# Memorandum

**To: Ryan Harriman**  
**From:** John Kenney, City Arborist  
**Subject:** SUB21-006  
**Date:** November 21, 2022

1. The tree protection fence will be 6' chain link fence. This will be put at the arborist given limits of allowable disturbance. For tree 22 the fence will be moved to the south.
2. A Qualified Arborist on site for all excavation within saved trees driplines with air excavation to locate and clean-cut roots encountered at limits of disturbance.
3. Limits of excavation for future detention system will not encroach into tree 13's tree protection zone.
4. A full replanting plan with drip irrigation for replacement trees will be provided during building plan review. None of the building permits will be approved without a preliminary replanting plan for all three lots. And a final replanting plan for the lot in review. Eighteen trees will need to be planted on any of the three lots.

# RAND-MILESTONE 3 LOT PRELIMINARY SHORT PLAT

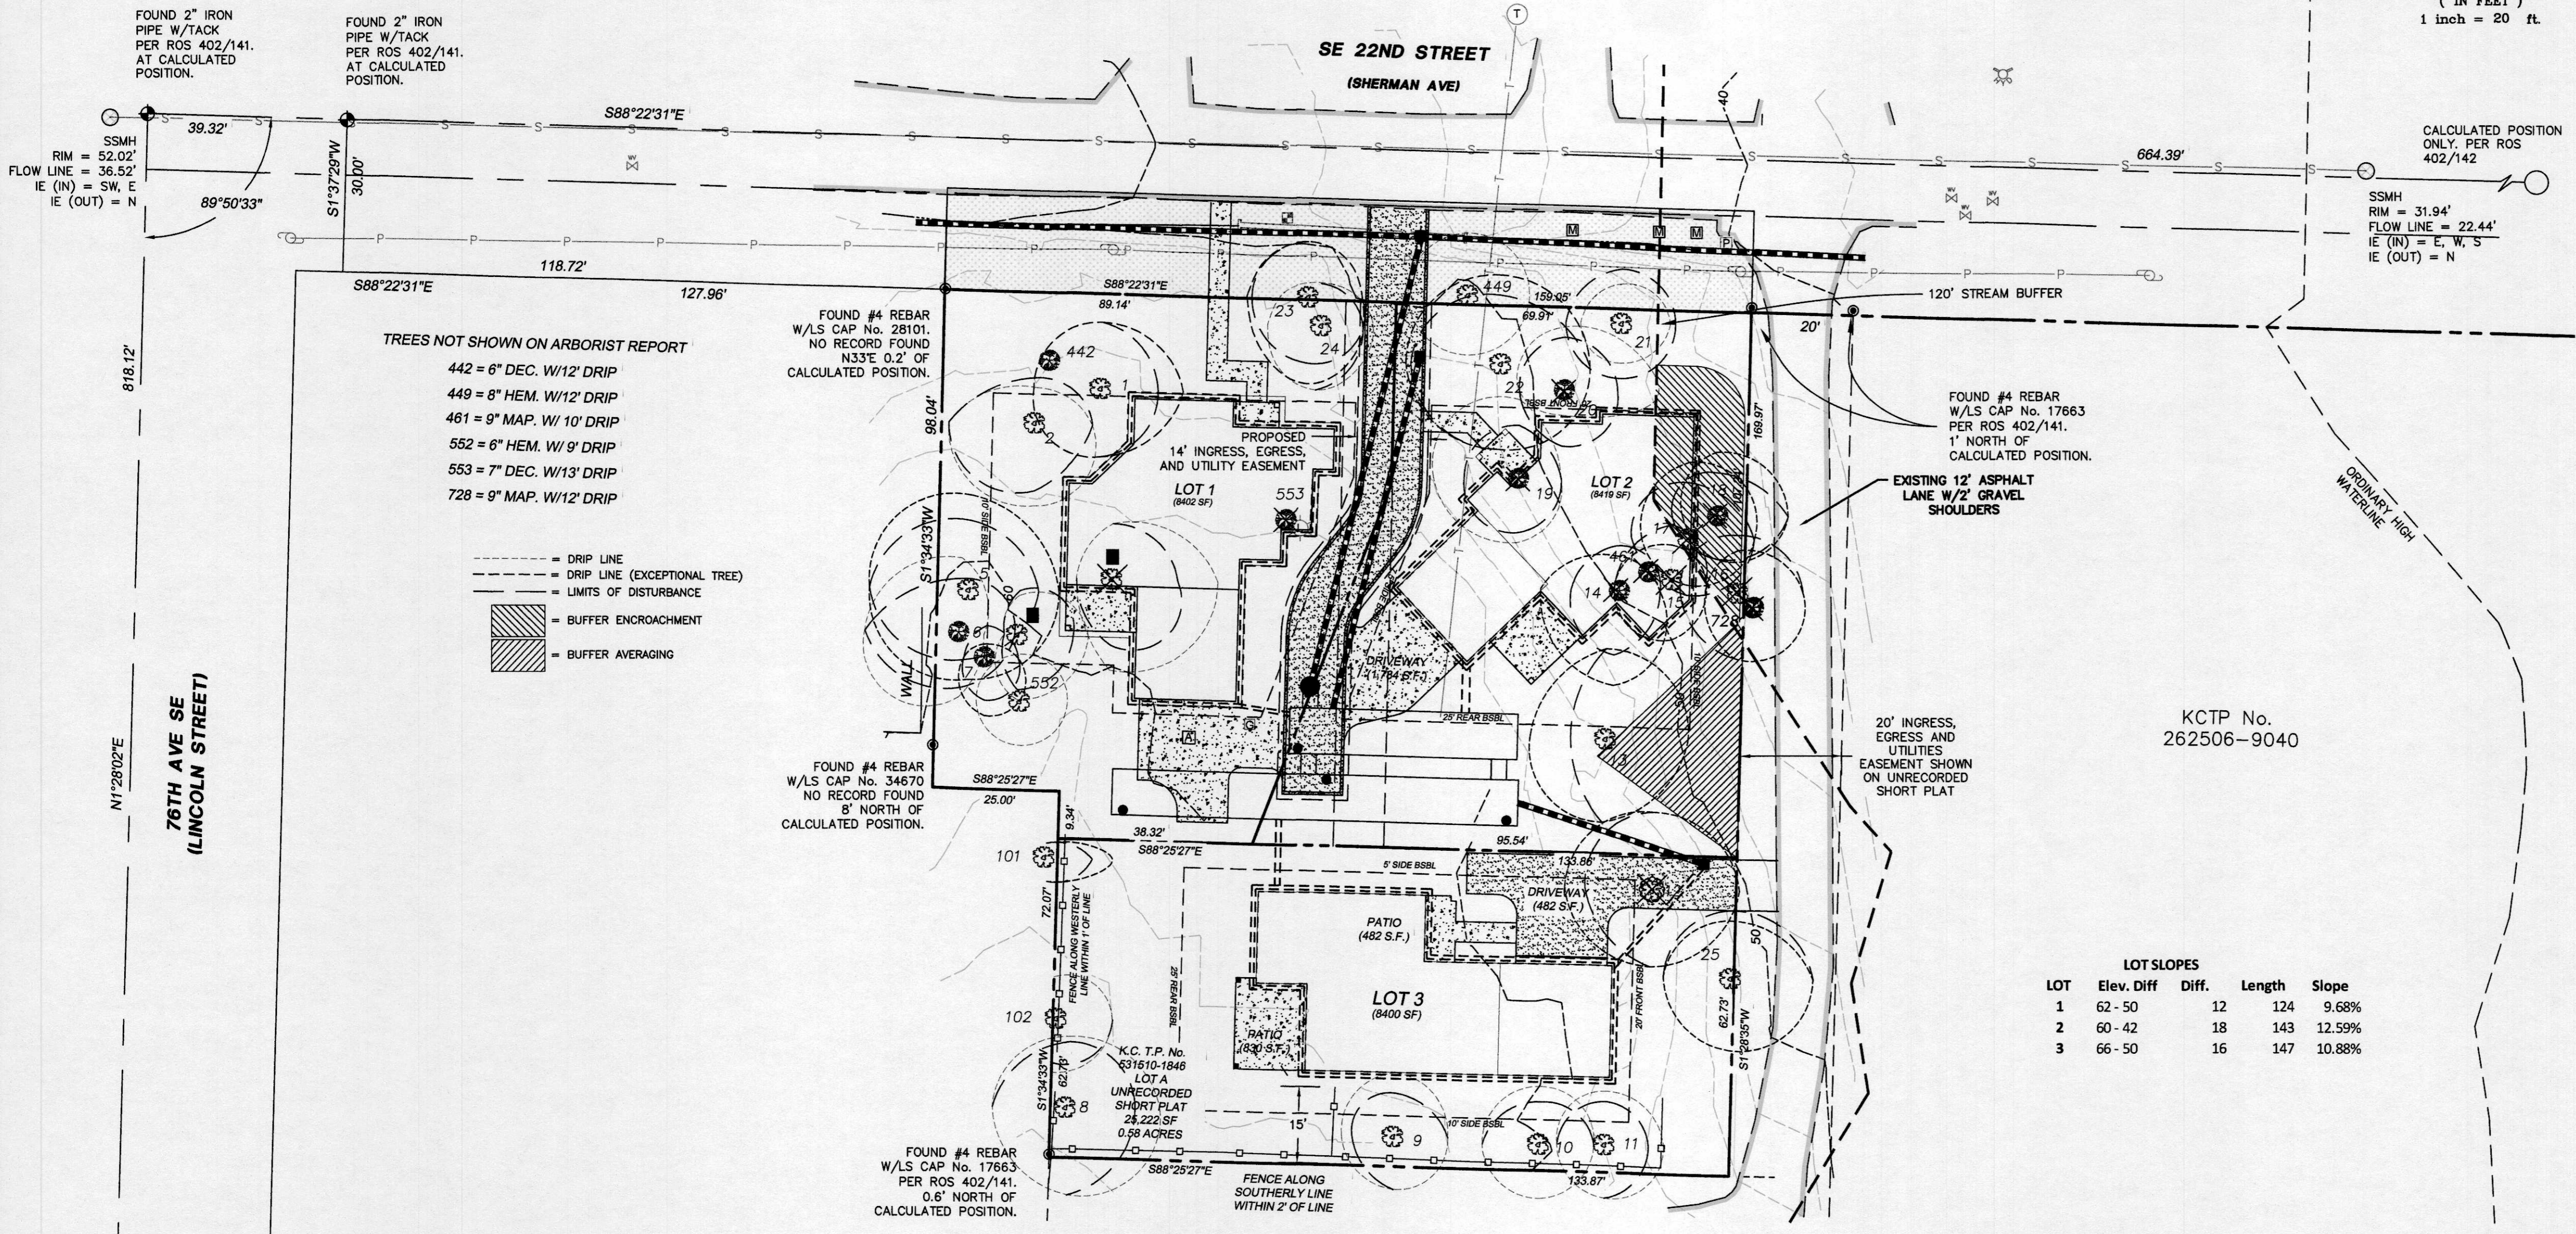
1. No tree identified for retention may be removed unless otherwise approved by the city arborist.
